KIRKLEES METROPOLITAN COUNCIL

**UPDATE OF LIST OF PLANNING APPLICATIONS TO BE DECIDED BY
STRATEGIC PLANNING COMMITTEE**

Planning Application 2025/92713

Reserved matters application pursuant to outline permission 2023/92079 for erection of residential development of 10 dwellings, demolition of existing extension at 27 Moor Lane, widening of existing access and realignment of boundary walls and discharge of details reserved by conditions 4 (noise), 5 (BEMP), 6 (Arboricultural Impact Assessment), 7 (safety and security), 8 (landscape), 9 (LEDS)

PLOT 1

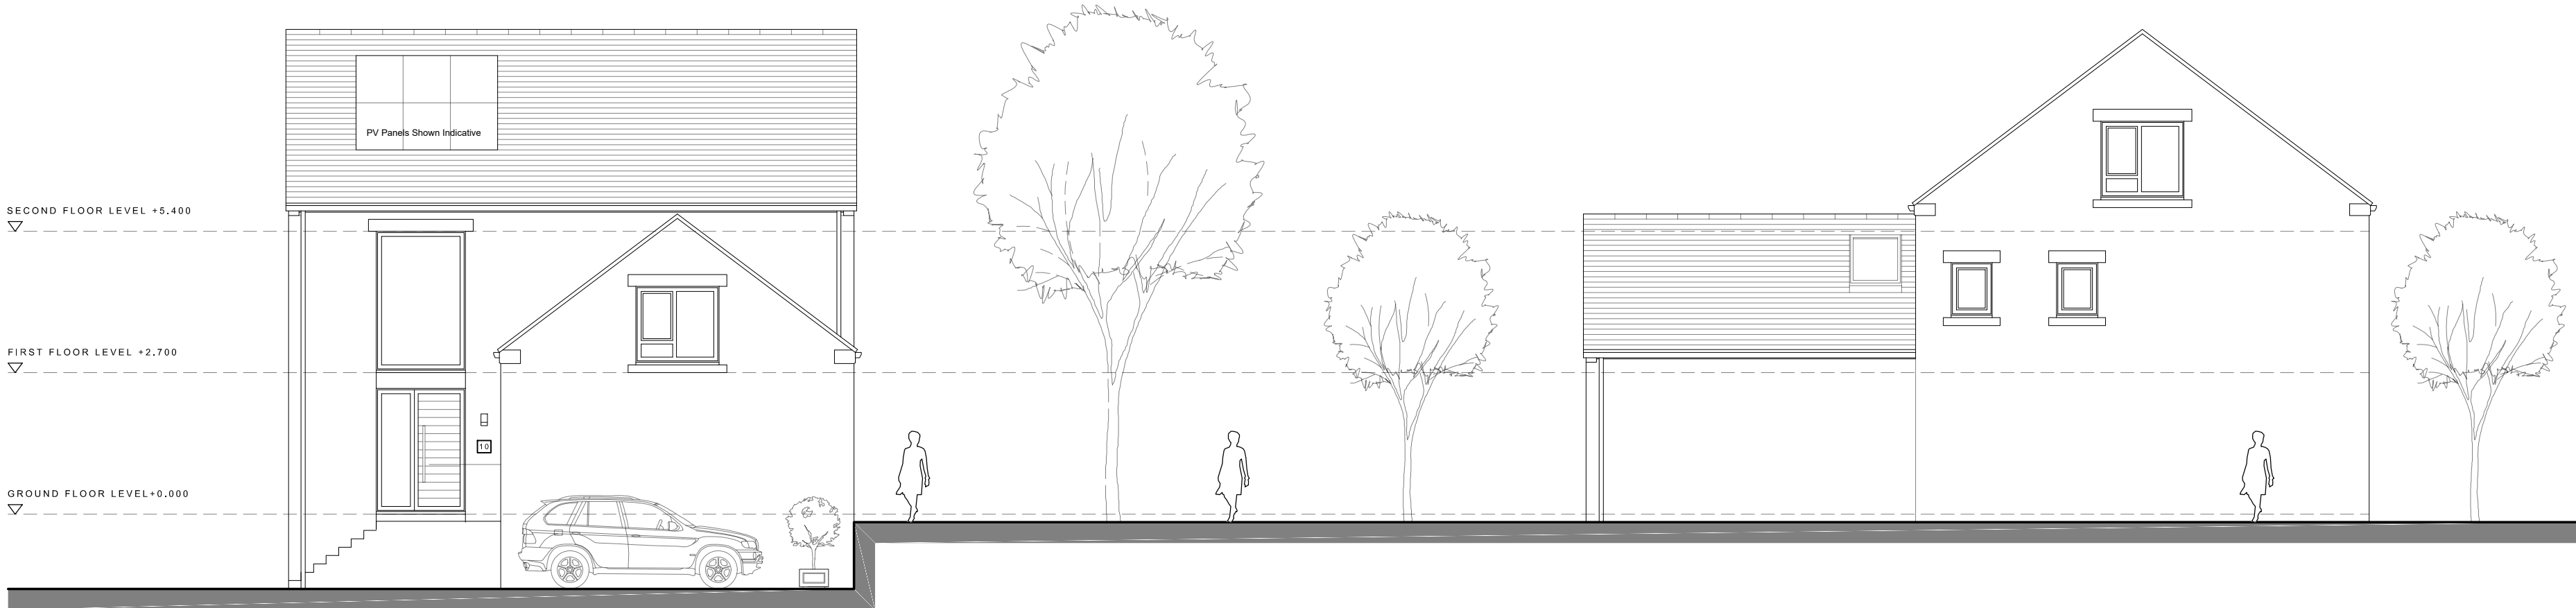
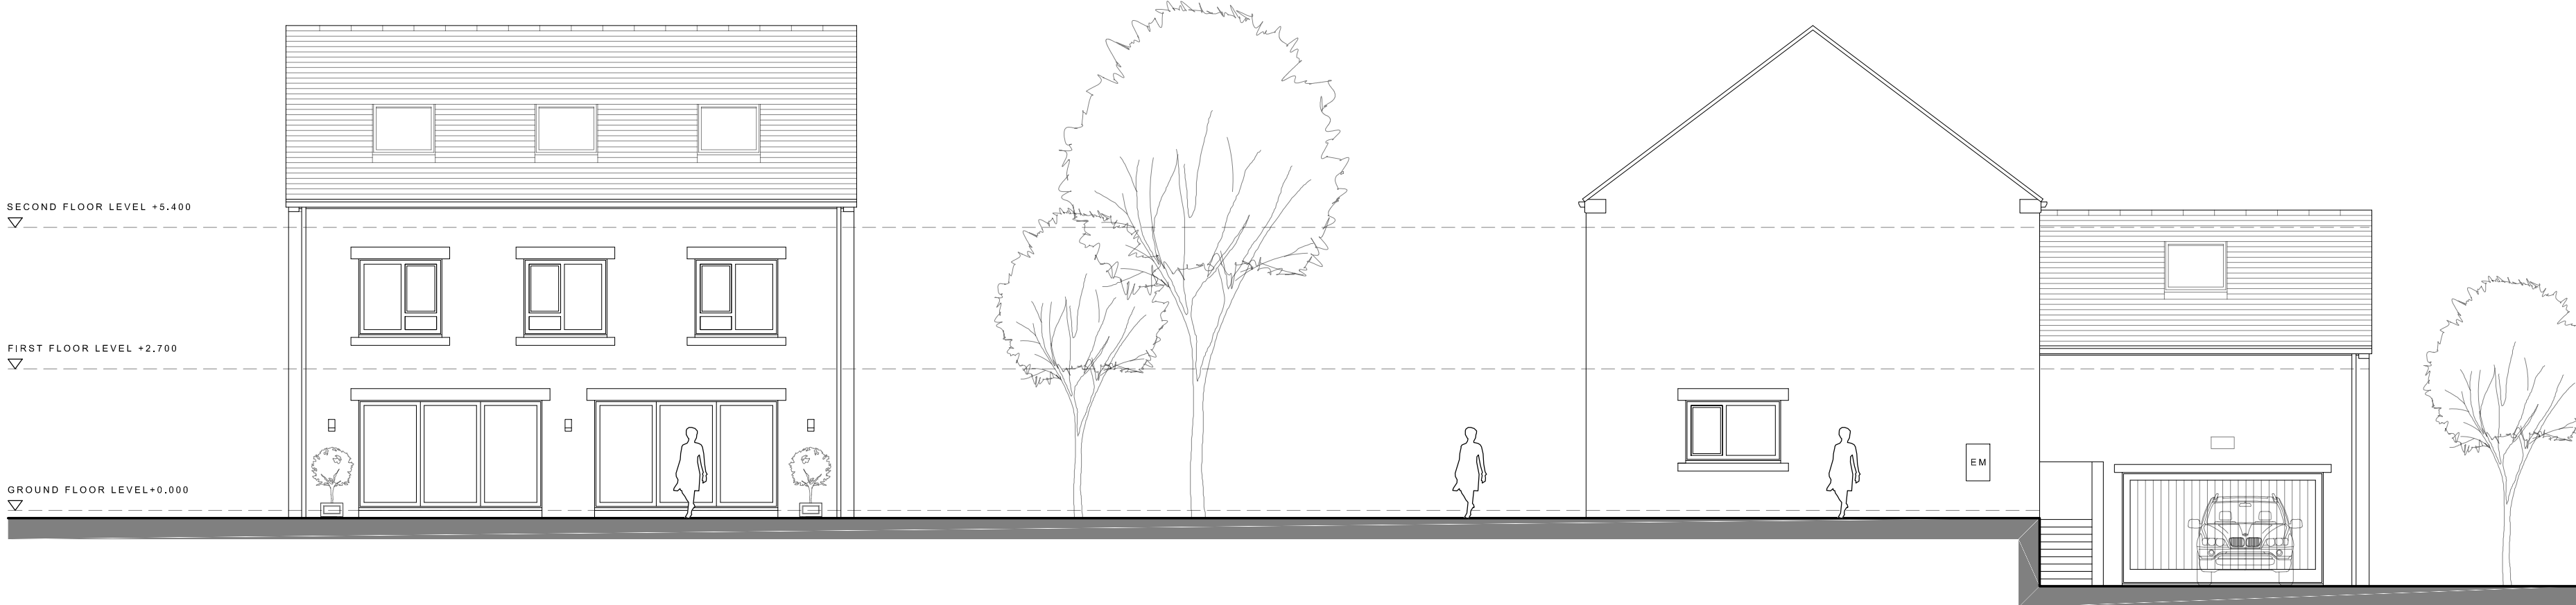
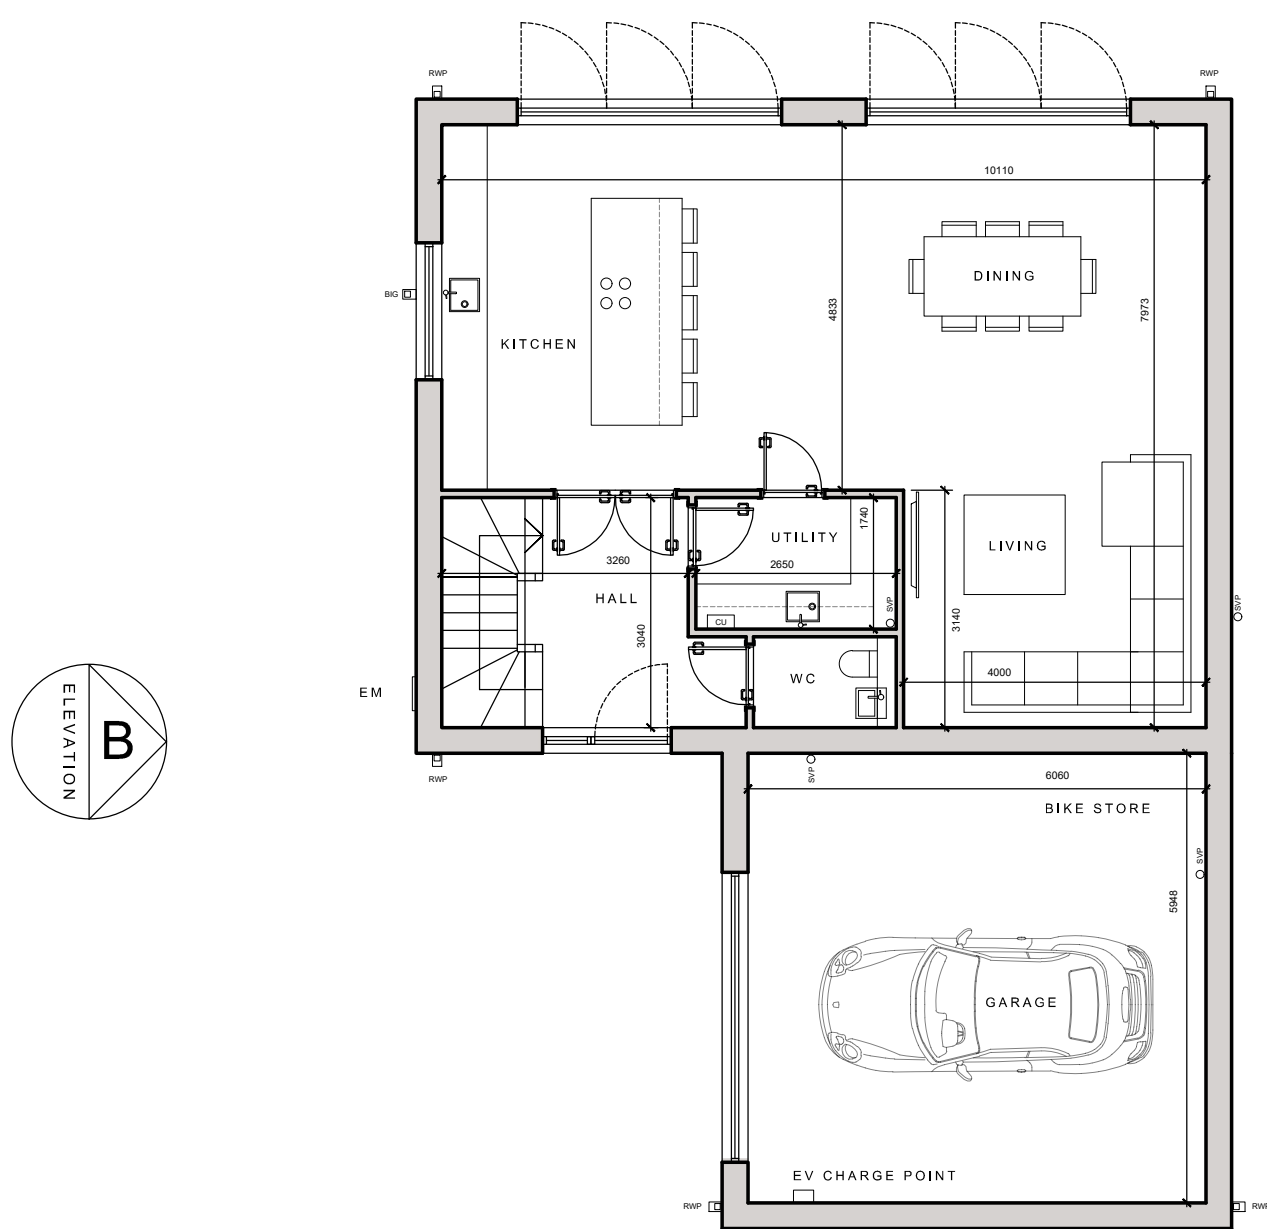
- Plot 1 (HT04) is referred to as a 5 bed, 7 person at 3 storeys 125m² Proposal 225.21m². In 10.44 Plot 1 is referred to a 2 storey building. Planner's advise this plots' eaves will be higher, consequently the ridge tiles will be higher. This makes Plot 1 taller than a 2 storey building. Planning are bending the rules and not adhering to the principle (2 storey buildings only) on which the previous committee meeting passed the original outline planning permission for this site. This plan is placing a 3 storey building in the vicinity of a grade 2* listed building which contravenes previous planning concerns that were raised at outline planning committee meeting.

Officers Response – Plot 1 is proposed to have two storey elevations and has additional accommodation in the roof space which would be lit by roof lights. K.C Conservation and Design have considered the proposal and do not raise concerns about the impact of this plot, including its massing or height on the setting of the Grade II* Listed building.
